DRainage V_1.pdf Markup Summary

FILINGS 1 AND 2
tracts AA and BB, Hannah Ridge
Subdivision Filing No. 1)
PUDSP-19-004
SF-19-006
SF-19-007
March 2019

PUDSP-19-004
SF-19-006
SF-19-007

(SEE HANNAH RIDGE AT FEATHERGRASS FILING NO. 1 FDR)

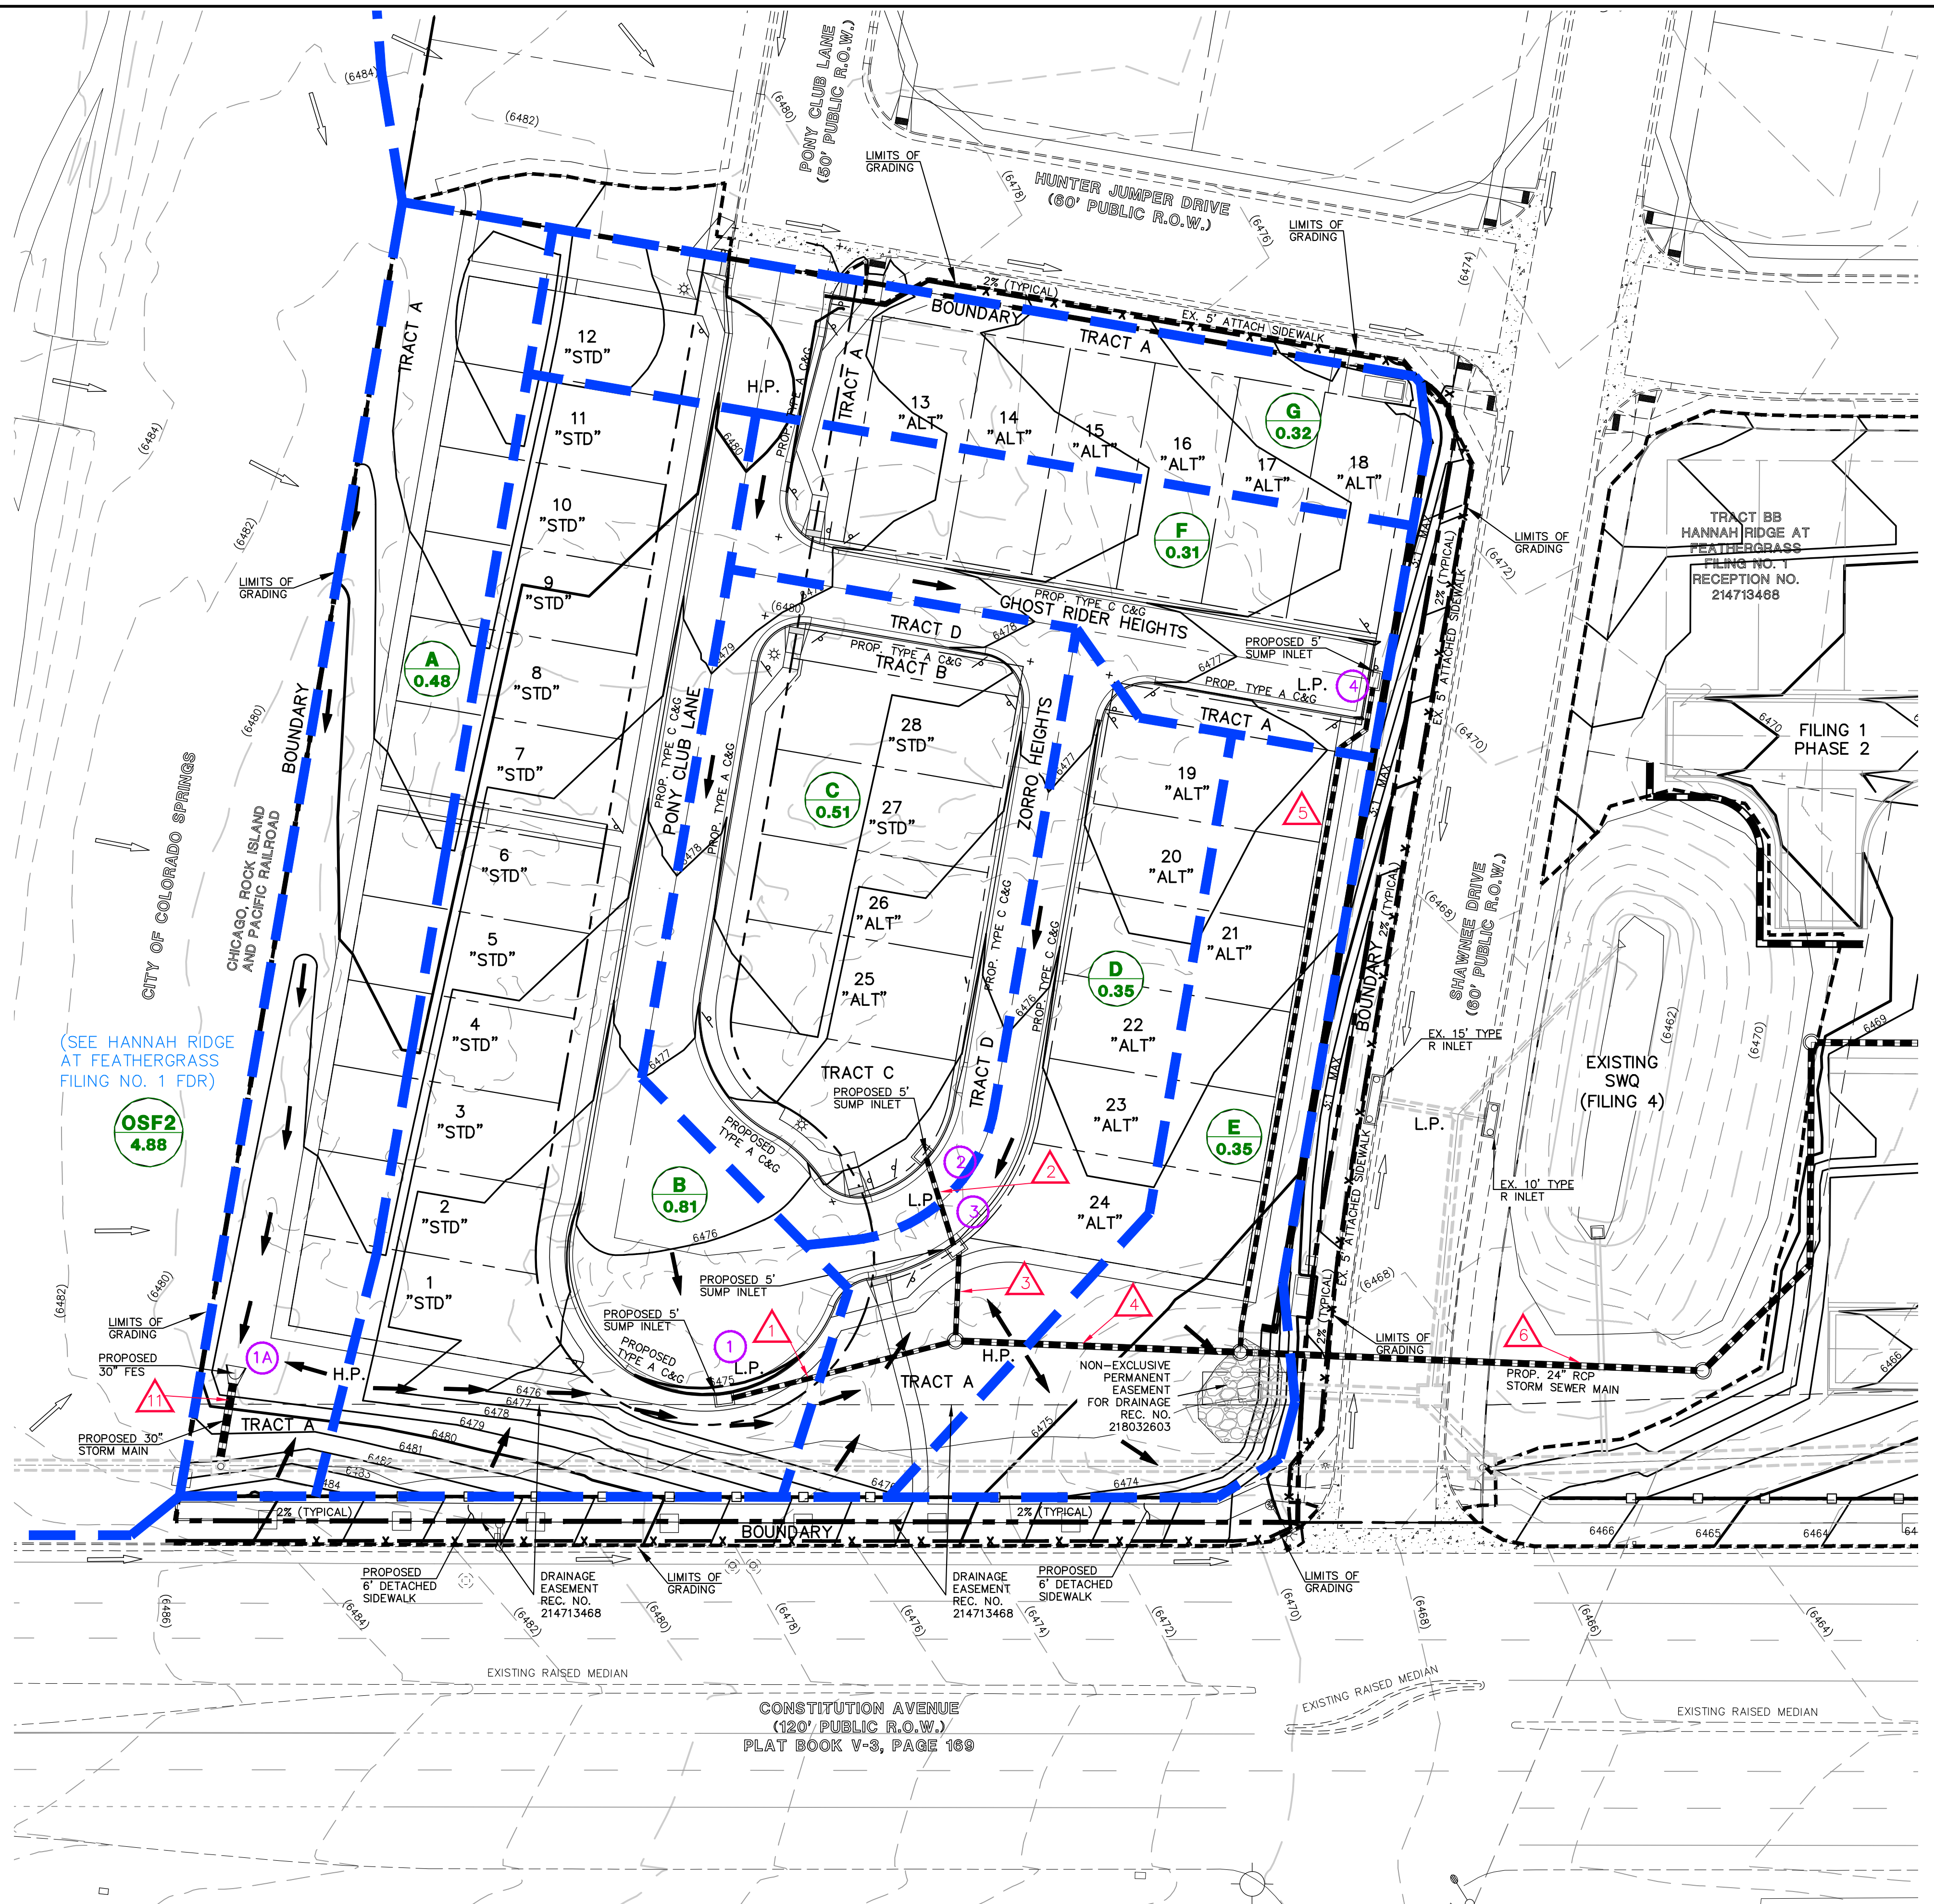
Call out design point 9.

Call out design point 8.

Basin E needs to flow to a Detention SWQ facility.

Provide a summary of all design points for all design flows. In a table, on these plans. Sheet 33?
Darken design points so they can be identified on a printed version.
Basin E needs to flow to a detention/SWQ Facility.
